From: Claire Potts
Sent: 12 March 2019 17:03
To: Planning.Responses
Subject: FW: AL/118/18/OUT Ryefields Farmhouse

WEST SUSSEX COUNTY COUNCIL CONSULTATION

TO:	Arun District Council FAO: Claire Potts
FROM:	Highways, WSCC: Tim Townsend
DATE:	15th February 2019
LOCATION:	Ryefields Farmhouse, Oak Tree Lane, Woodgate, Chichester, PO20 3GU
SUBJECT:	AL/118/18/OUT Outline application with some matters reserved for the demolition of existing buildings & the erection of 10 No. dwellings comprising 1 No. three bedroom detached, 2 No. three bedroom semi detached, 4 No. four bedroom semi detached & 3 No. four bedroom detached houses with associated access & parking. ADDITIONAL INFORMATION RECEIVED.
DATE OF SITE VISIT:	22 nd and 26 th November 2018
RECOMMENDATION:	☒ Advice ☐ Objection ☐ Modification ☐ No Objection ☒ More Information ☐ Refusal
S106 CONTRIBUTION TOTAL:	£7,130 per-dwelling contribution towards highways infrastructure to support the BEW Strategic Allocation. Non-highways found at foot of this report.

Rev A 30.01.2019
Access amended and grasscrete area added
Verge cut back; kerbline adjusted; bin
collection areas re-located.

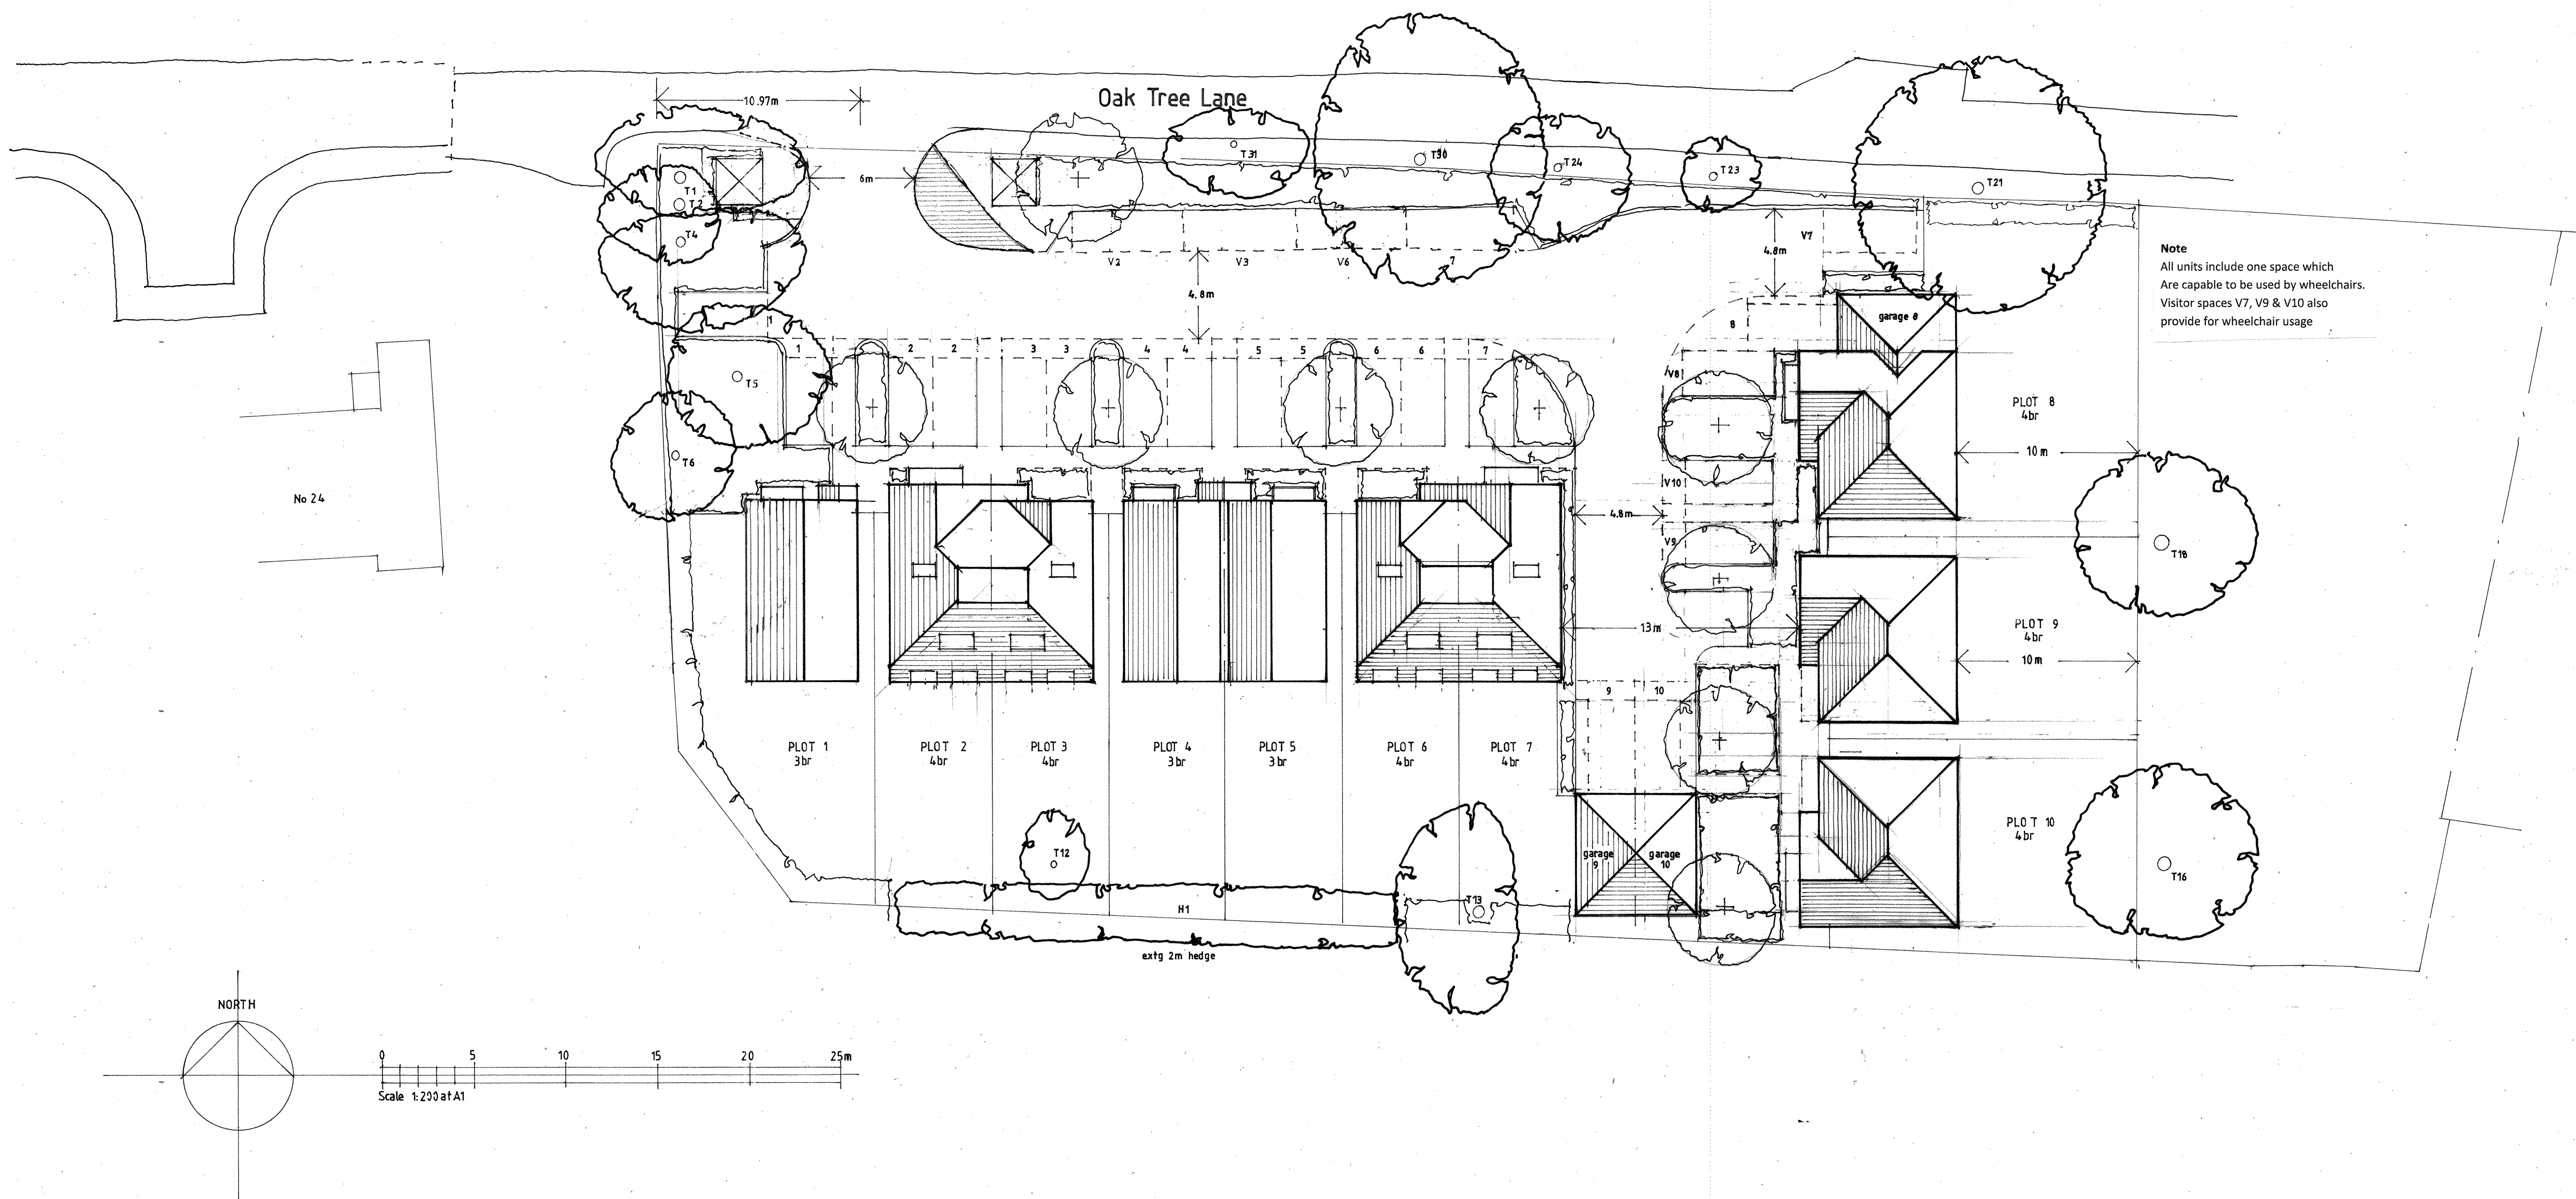
- 3. Visibility splays at the access point to the site (and bin stores moved clear of them).** Now shown on 'Site Access Visibility' drawing (Jan 2019). The splays of 15m and 23m (west and east respectively) taken from a 2.0m 'x'/centreline distance concur with Manual for Streets (MfS) guidance for a lightly-trafficked road/access and where vehicles would be travelling at 12mph from the west and 19mph from the east. Given the current layout of the road, its surfacing (unmade on the section of the lane where the access joins it), observed low vehicle speeds and low frequency of traffic movements, the CHA consider that what is shown would be adequate for purposes of this planning application.

- 5. Swept-path diagrams demonstrating access to-and-from the site through the site access and also demonstrating the ability to turn within the site for fire appliances and refuse vehicles.** Now shown on 'Refuse Access', 'Refuse Egress', 'Refuse Turning Head', 'Fire Tender Access', 'Fire Tender Egress' and 'Fire Tender Turning Head' drawings – all Jan 2019. Both the refuse and fire appliance vehicle dimensions used for tracking appear too small. As such, the applicants should re-submit the tracking diagrams with larger vehicles. Advice about size of vehicles can be obtained from both the local Waste contractor (via Arun District Council) and WSCC Fire and Rescue Service.

Additional information demonstrating suitable access by both fire appliances and refuse vehicles is required from the applicant in order for the Highway Authority to consider the proposal further.
